NEW HOME, INC.

Plan 05 - The Apex
Garage Right

PROJECT #: 21-2780.1-A (Lot 41, WS)
PAGE: 1 OF 1
JUNE 6, 2024
RE: CAFE HEADER BEARING

S-2.1

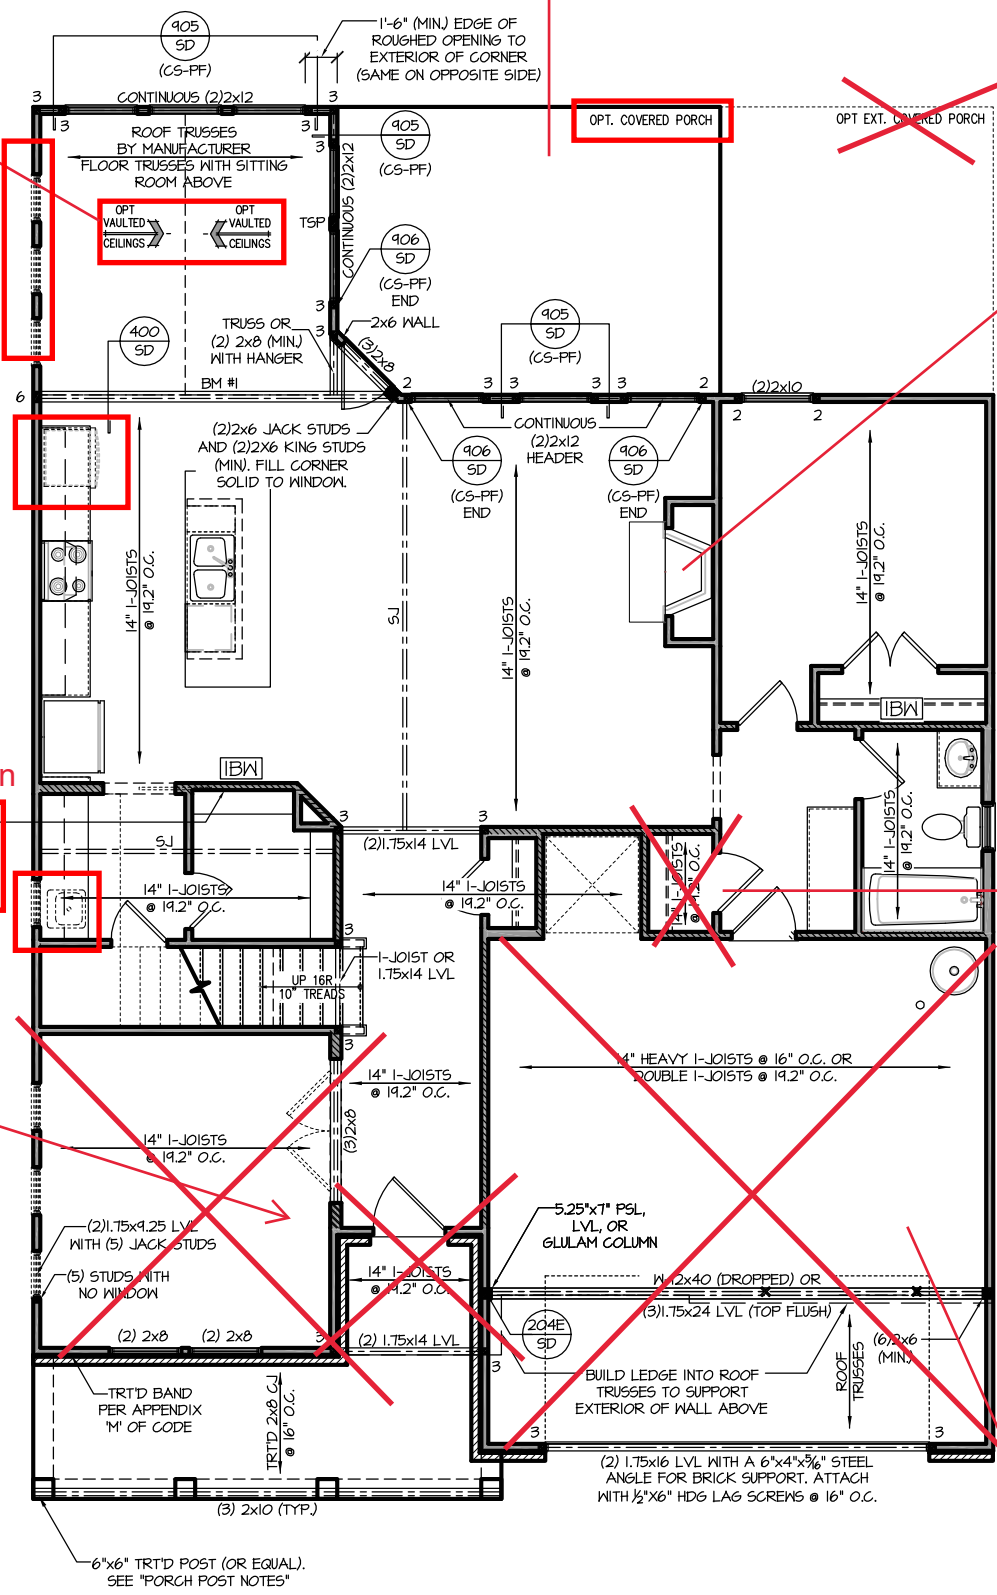
**(2)2x10 INSTALLED HERE SUPPORTS A SINGLE VAULTED TRUSS BUT ONLY THE RIGHT 2X10 PLY HAS BEARING ON THE WALL. THE (2)2X10 EXTENDS APPROXIMATELY 48" FROM THE BEAM TO THE NEXT ADJACENT TRUSS. THE (2)2X10 IS HANGERED TO THE BEAM AND TOENAILED TO THE NEXT TRUSS.
NOTE THE (2)2X10 AND SINGLE PLY BEARING ARE OK PROVIDED THE (2)2X10 PLIES ARE ATTACHED WITH (3) ROWS OF 12d NAILS @ 8" O.C.**
